From: Carmichael Ian <Ian.Carmichael@thamesvalley.pnn.police.uk>
Sent: Wednesday, September 18, 2019 11:50 AM
To: Samantha Taylor <Samantha.Taylor@Cherwell-DC.gov.uk>
Cc: Planning <Planning@Cherwell-DC.gov.uk>
Subject: Planning ref: 19/01705/OUT. Land Adj and West of Bloxham Rec Ground South Newington Rd Bloxham.

Planning ref: 19/01705/OUT. Land Adj and West of Bloxham Rec Ground South Newington Rd Bloxham.

Crime Prevention Design Advisor | Oxfordshire | Local Policing | Thames Valley Police

Figure 5.5: The proposed movement strategy creates an integrated development.

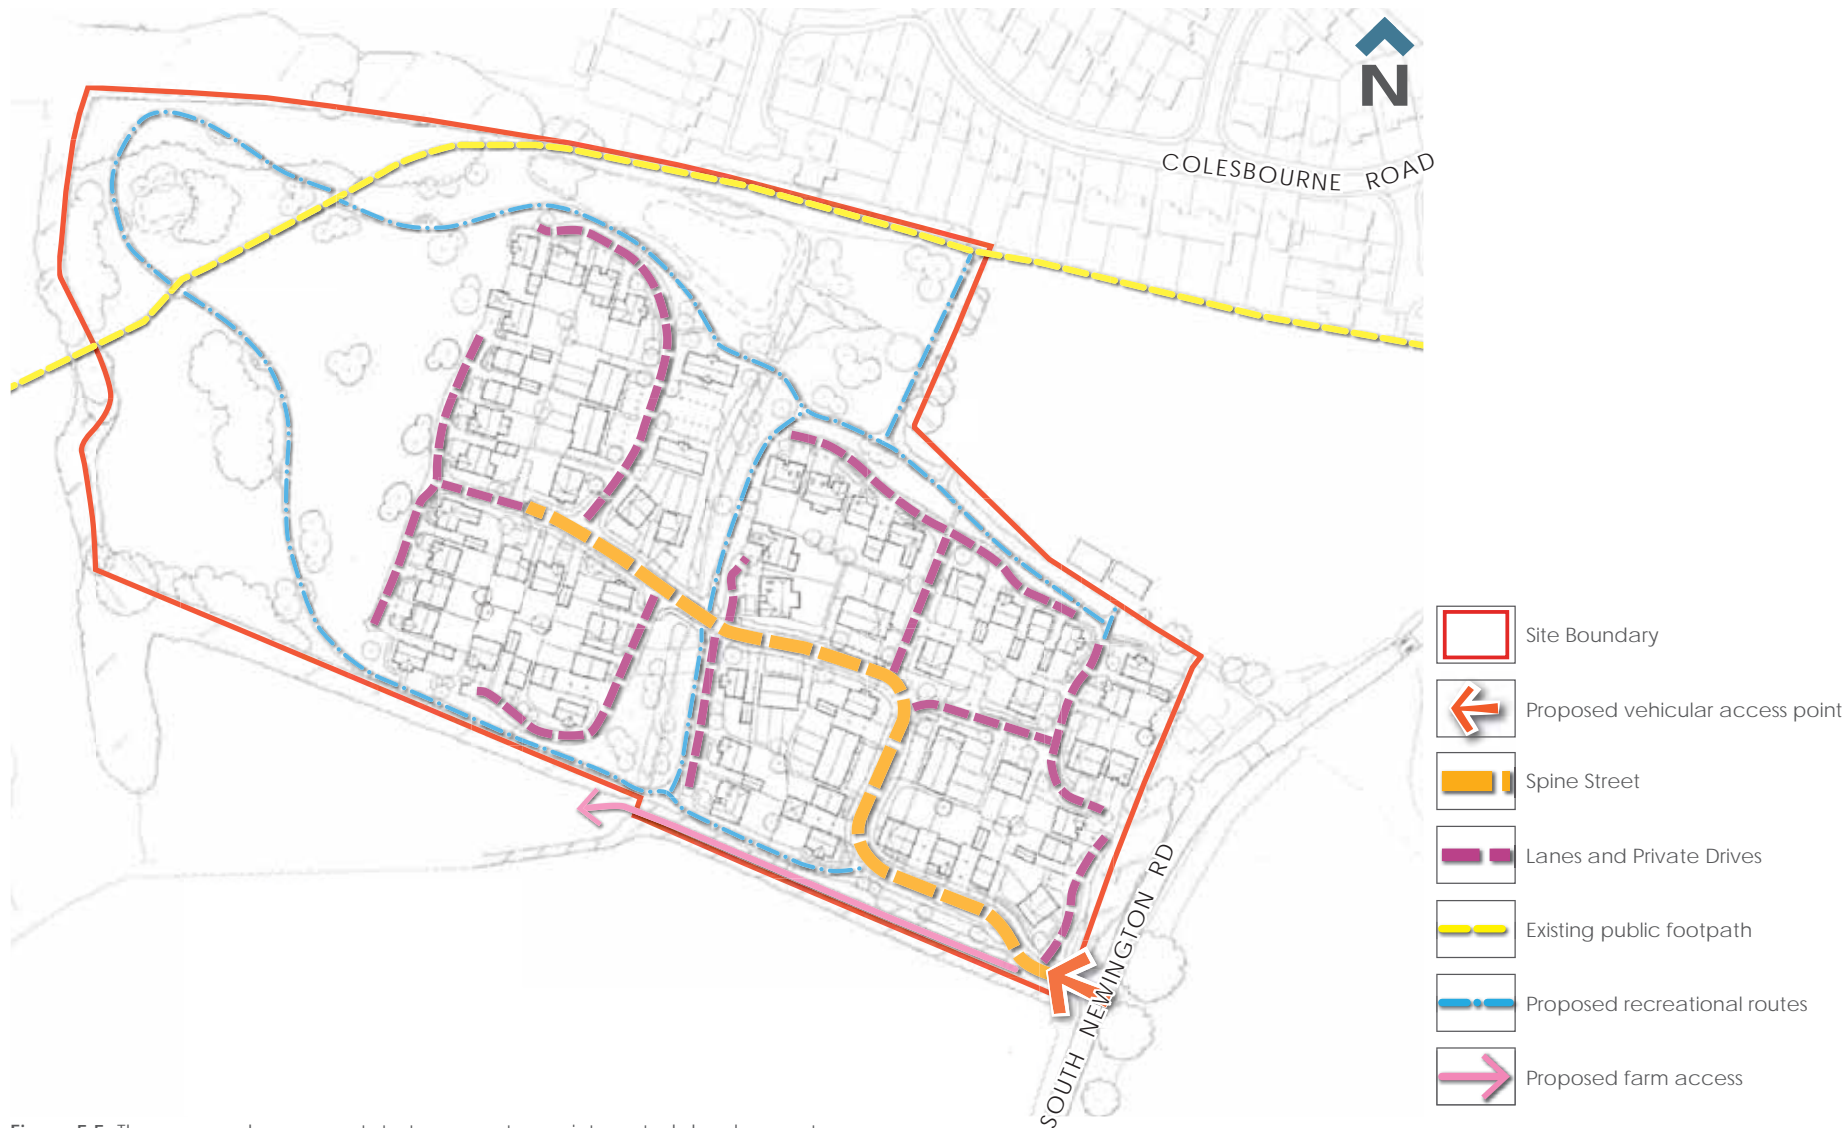
- Permeability is always a desirable quality within new development of this size/type. Although this can be helpful in creating active places, inappropriately high levels of permeability are likely to attract crime/anti-social behaviour (ASB), aid criminal search behaviour and provide escape routes for offenders. For future reference, all routes should be direct, serve a defined purpose and not be segregated or make the rear of properties vulnerable. Permeability for permeability's sake should be avoided. An example of this is that there are three proposed routes leading north from just the east half of the site. One would suffice and I recommend that two of the routes are omitted.

Figure 5.7: 'Designing out crime' Principles.

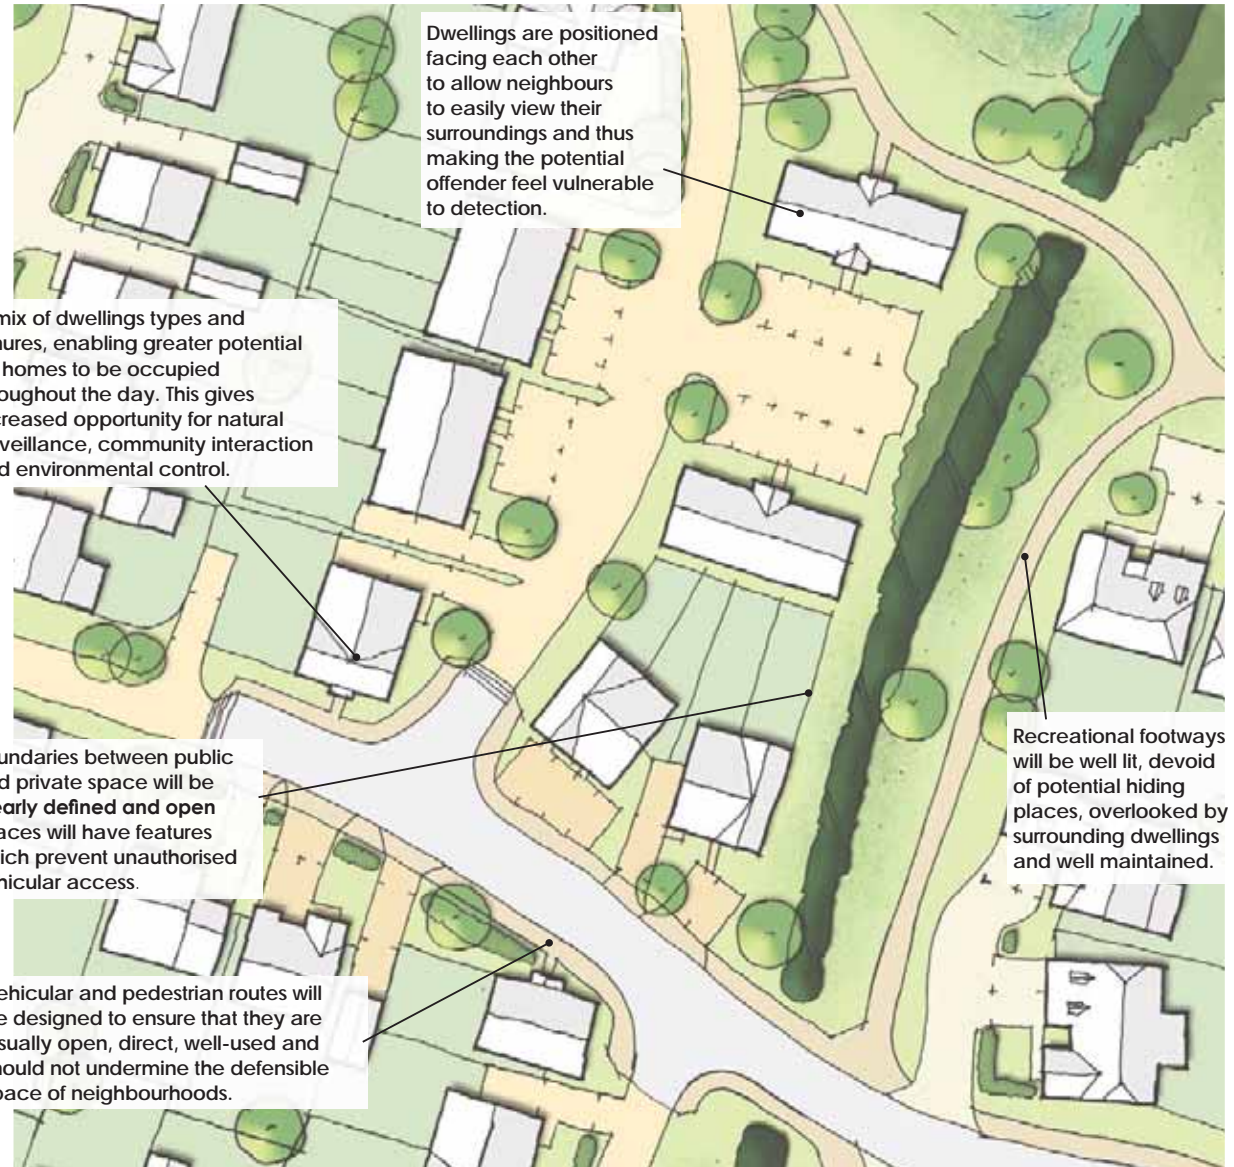
- The DAS says that parking will have walls as boundary treatments. Although not a problem in principle, walls can restrict oversight of parking areas in some situations. Parking should always be overlooked from windows of active rooms of the dwelling/s it serves. In addition and for reference, where boundary treatments of private rear gardens abut public or semi-private space they should be of sufficient height (at least 1.8m) and incorporate features that make them difficult to climb; trellis on fences, angled or rounded copings on walls etc.
